RE: Staff Review Comments for Level III Preliminary Site Plan – Planning Board Review

Project Name:	Hotel Conversion- Former Gannett Building	Project ID:	2012-602
Address:	119 Exchange Street	CBL:	032C001
Applicant:	119 Development, LLC		
Planner:	Shukria Wiar

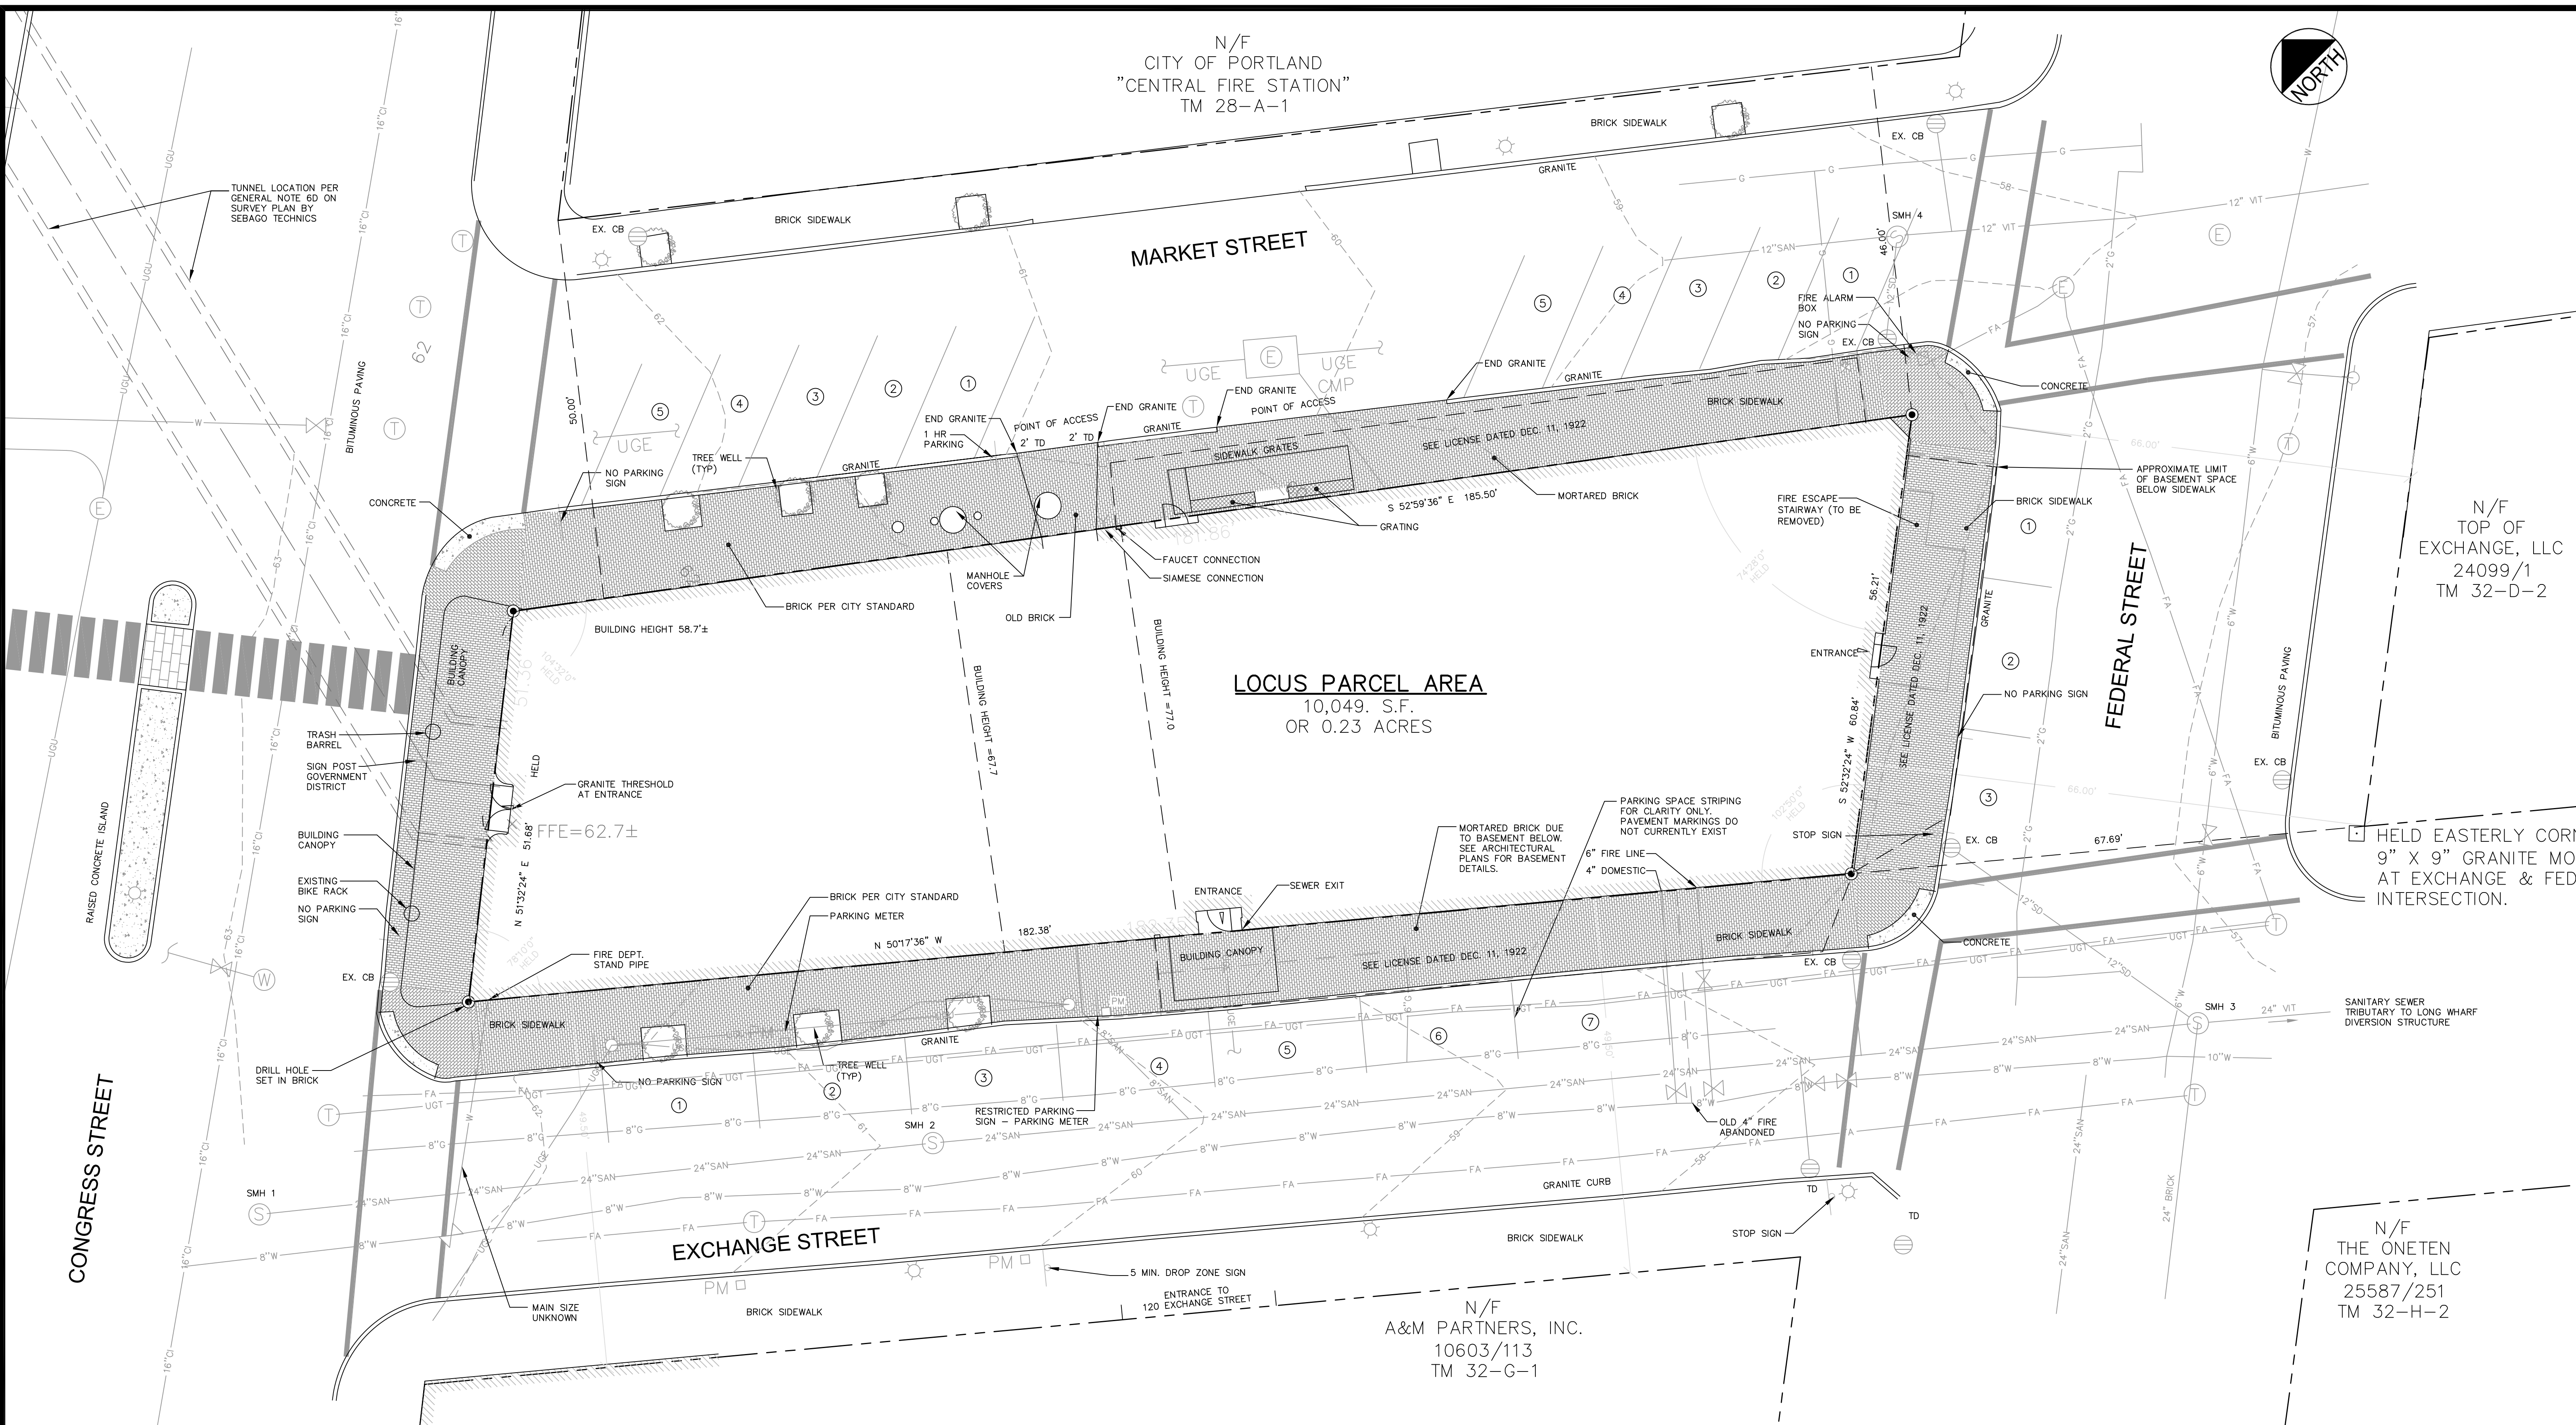
- a. Survey plan needs surveyor's stamp.
- b. Elevations are required to be based on NGVD 1929 Datum. Please state which datum was used.
- c. Question need for easements or licenses for canopies and underground vaults. What about license dated Dec 11, 1922? Please submit a copy of the license.

PERPENDICULAR ADA RAMP LAYOUT FOR WIDE SIDEWALK WITH NO ESPLANADE
N.T.S.

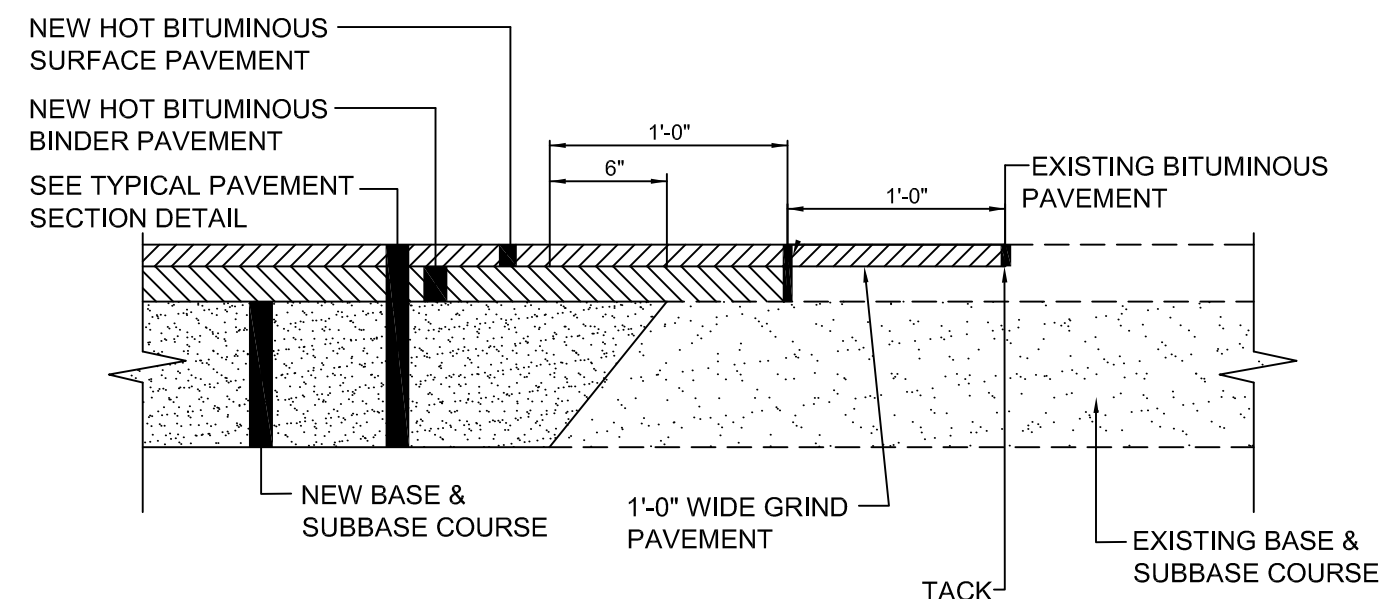
- f. The project will be upgrading sidewalks surrounding the building. Coordination with DPS on appropriate sidewalk ramp design and ADA compliance will need to take place.

- h. The sidewalk ramps at all four corners on this block are being reviewed by the City's Bike/Pedestrian Coordinator for possible revisions. These comments will be forwarded.

GREASE TRAP DETAIL
N.T.S.

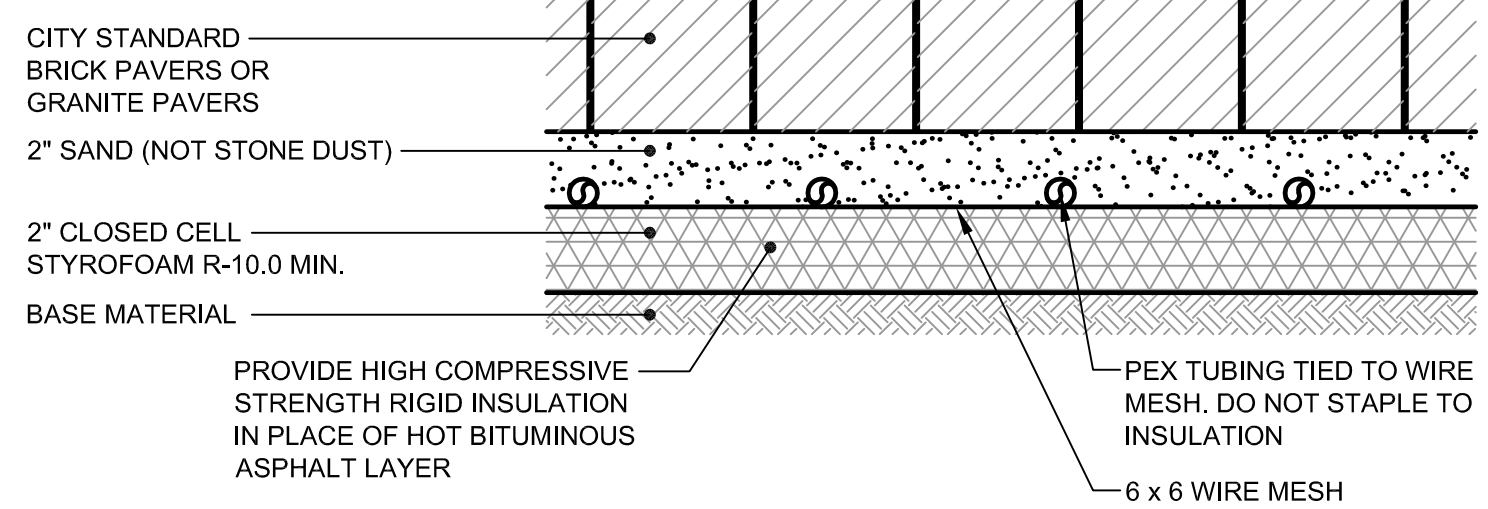
- d. The applicant is proposing an 80 seat restaurant. An external grease trap will be required. Please use Figure II-19 of Portland's Technical Standards for sizing and design requirements. The city would be receptive to reviewing a license agreement to allow the grease trap within the road right of way. The Exchange St. right of way seems to be a possible logical location.

BICYCLE PARKING RACK PLACEMENT
N.T.S.

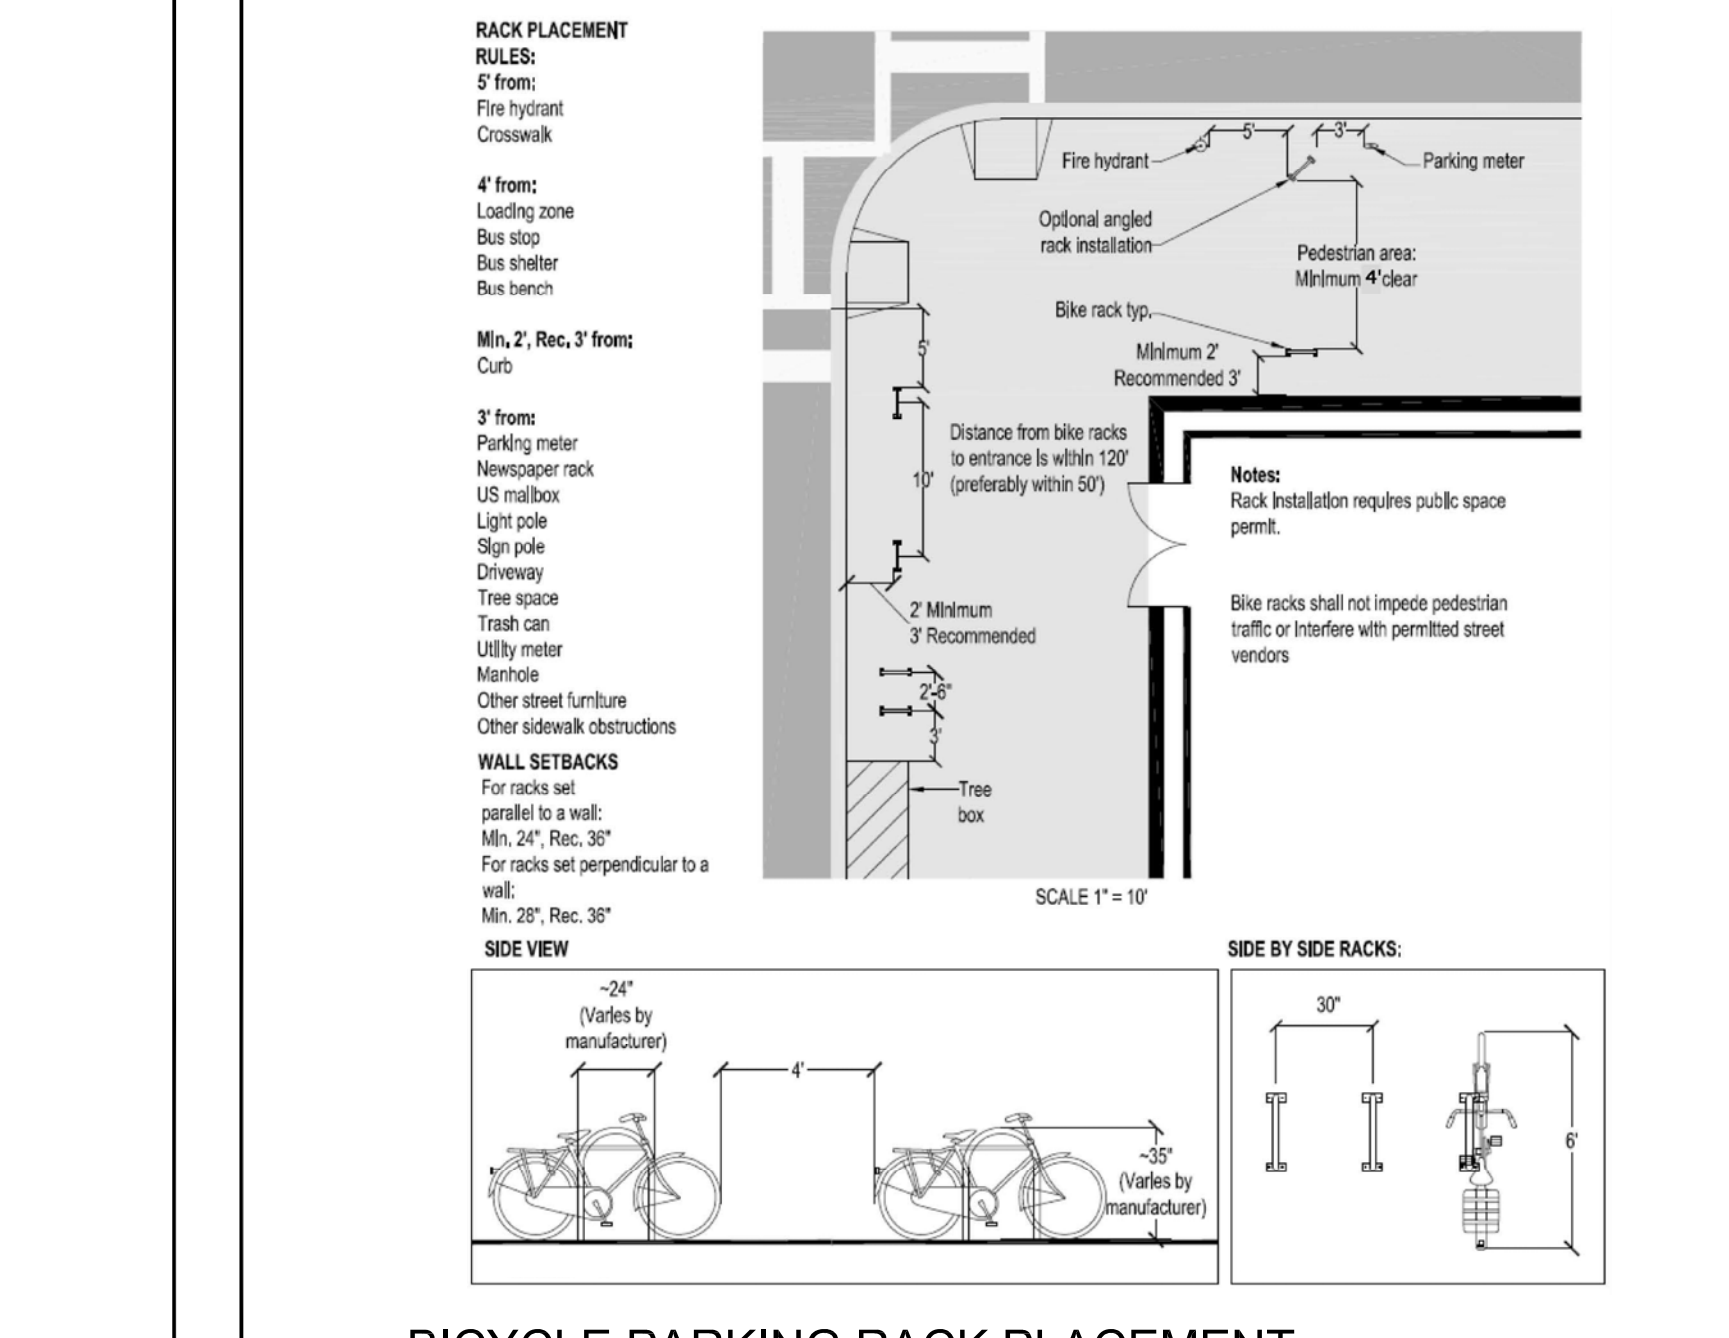
- a. The applicant is requesting a waiver for providing bicycle parking. In my professional opinion this project does not warrant a waiver from City standards.

- e. Show location of bike racks. Are the two proposed bike racks enough? Applicant is requesting a waiver of the bike standards due to use. Also requesting a waiver of scooter and motorcycle parking. Staff discussion is needed and comments will be forwarded.
